26 Wood Street
Skelmanthorpe
Huddersfield
HD8 9BN
12 August 2024

Planning Application 2024/91934 (11 Wood Street, Skelmanthorpe)

Project: Residential Development 11 Wood Street
 Skelmanthorpe HD8 9BN
 Title: Site Plan
 Scale: 1:200 @ A2
 Date: April 2025 Drwg No: LD/245.E (redrawn)

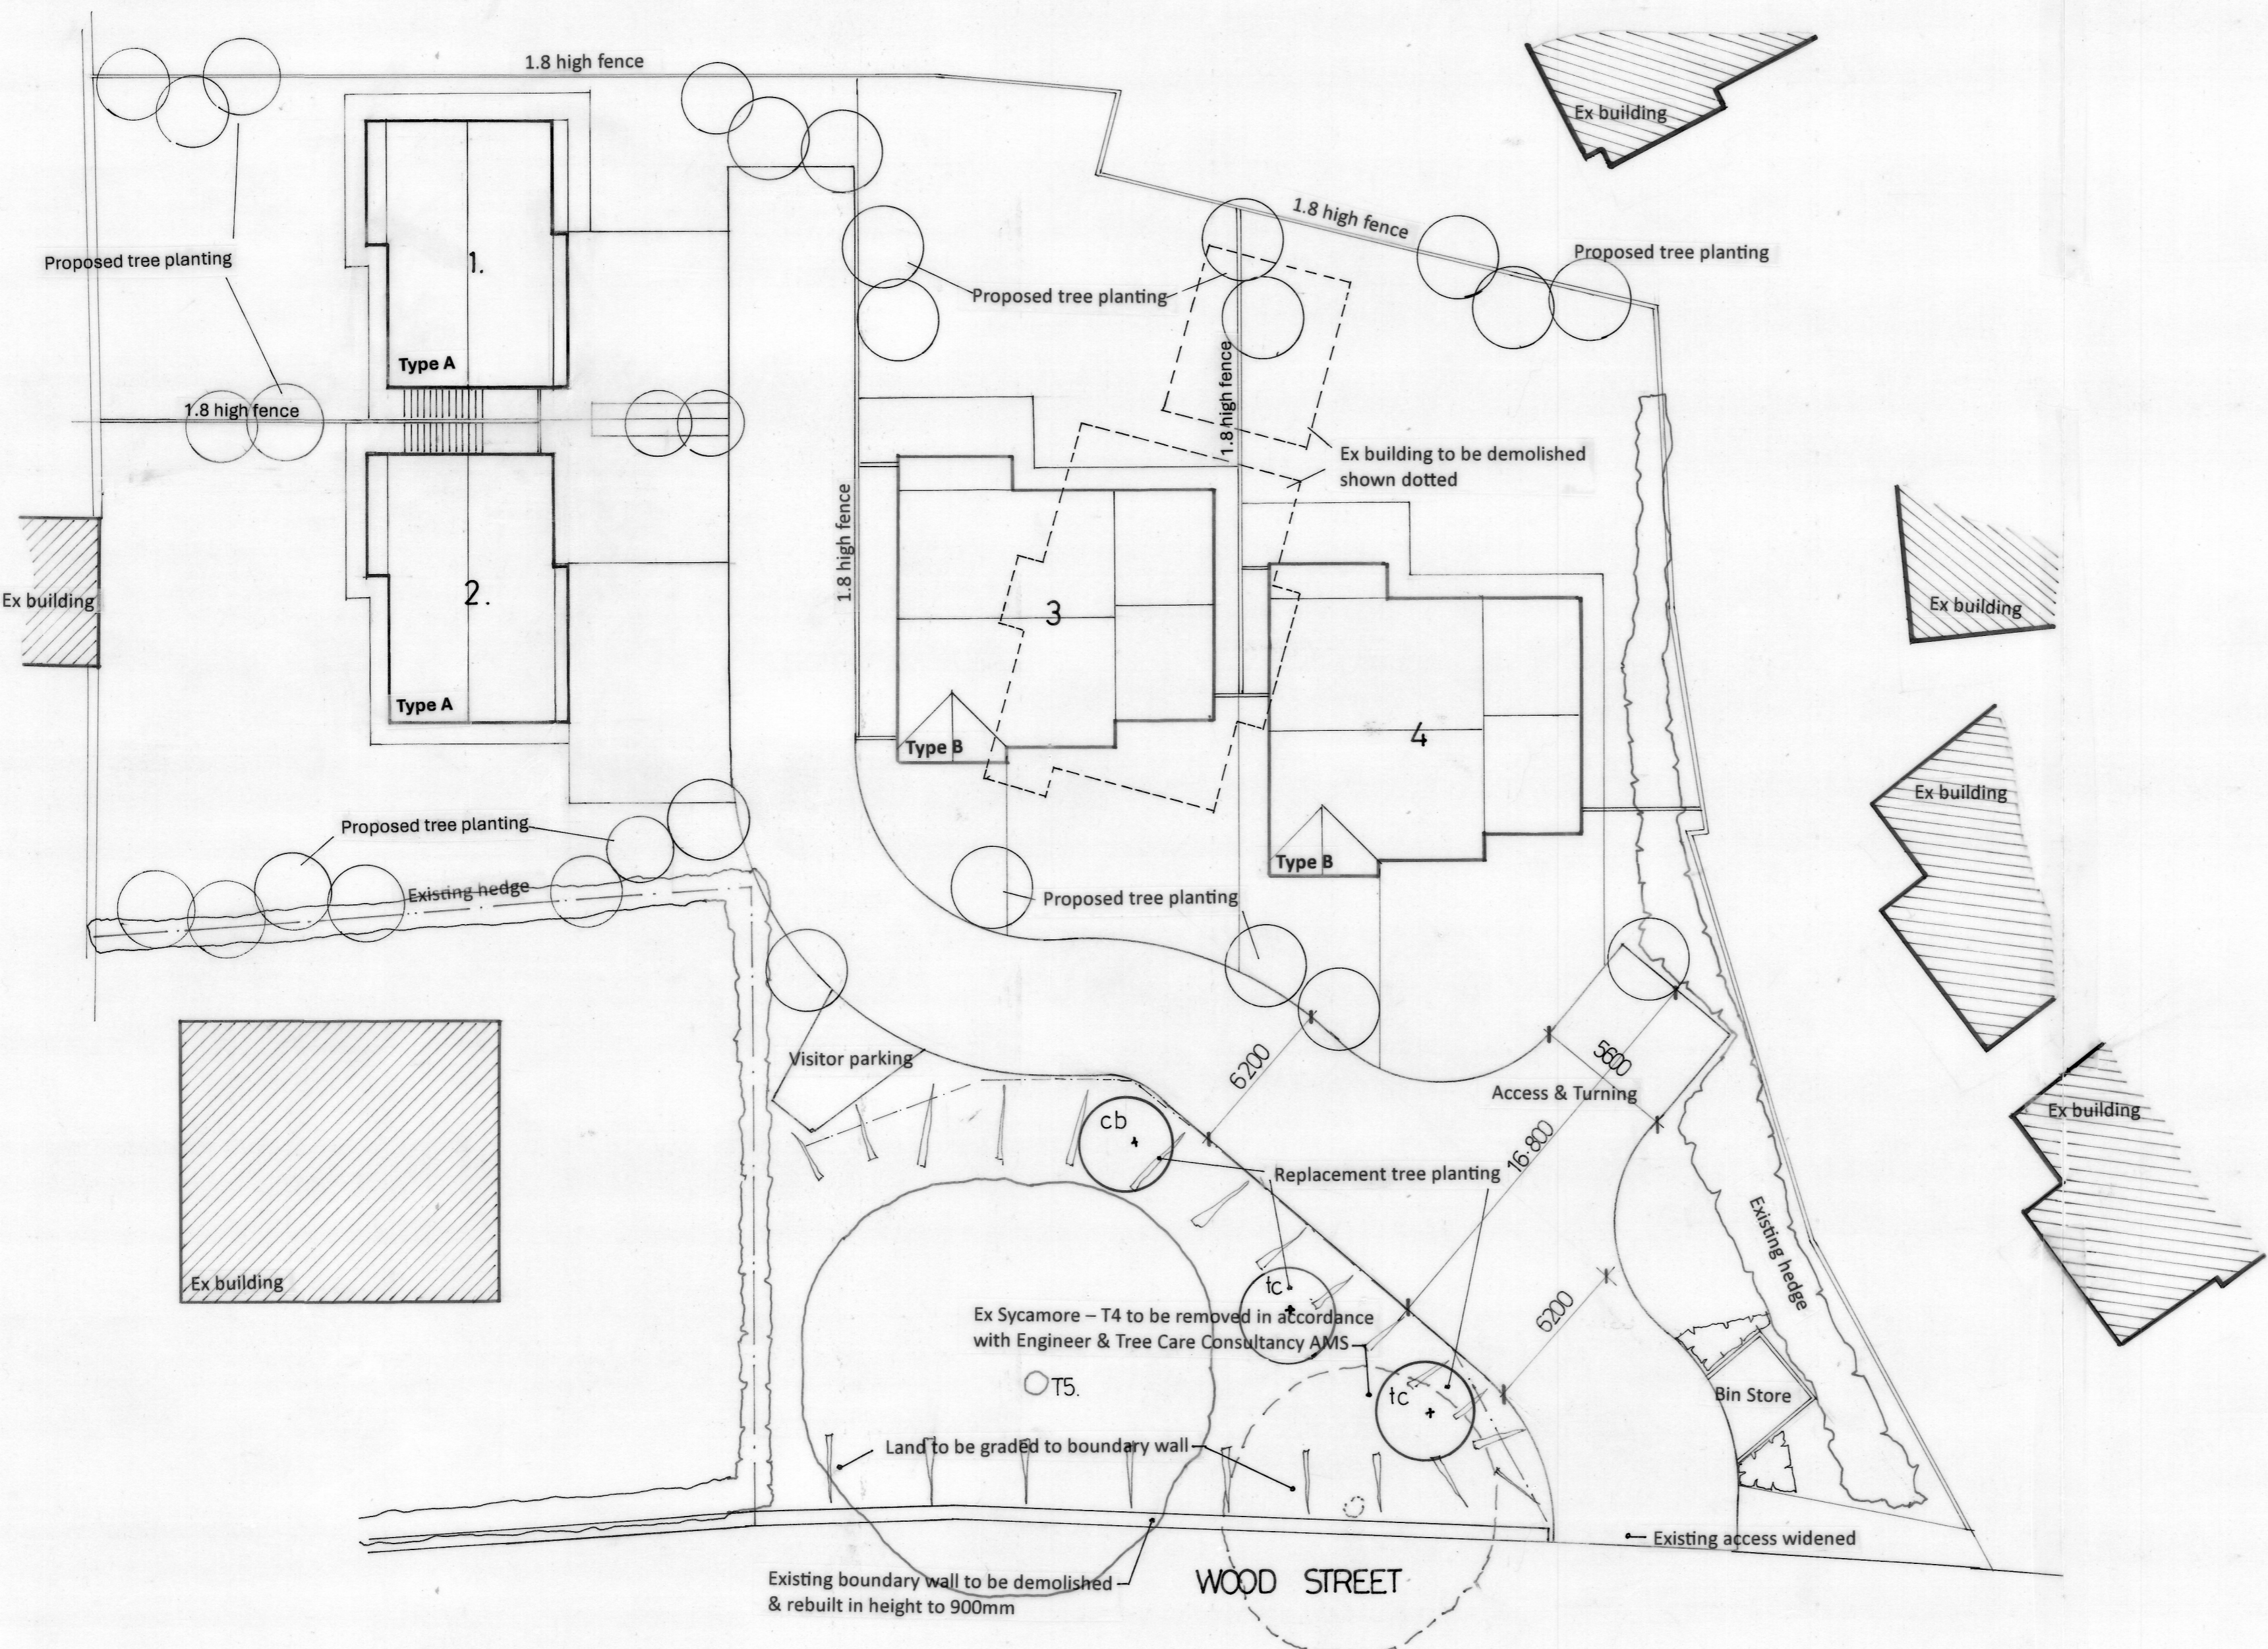
The building of the houses themselves will have little visible impact on us but there are consequences. To reduce the height of the wall running alongside Wood Street would markedly reduce the visual aspect of the street and the adjacent environmental area. We would object to that. However, although we are unable to see over the wall, we assume that this would have some effect on the healthy, mature Sycamore trees - felling perhaps? Once again this would adversely affect the Street landscape and we would object to that.

Looking at the plans it appears that the parking for visitors would be totally insufficient. Would further modifications be subsequently needed to increase this, and what would they entail? Four substantial dwelling houses would undoubtedly increase the flow of traffic into and out of Wood Street from Station Road. There are no pavements, the road is narrow, and the entrance is at right angles with a blind side. As it stands in this day and age this seems inadequate and we would object to it being unchanged.
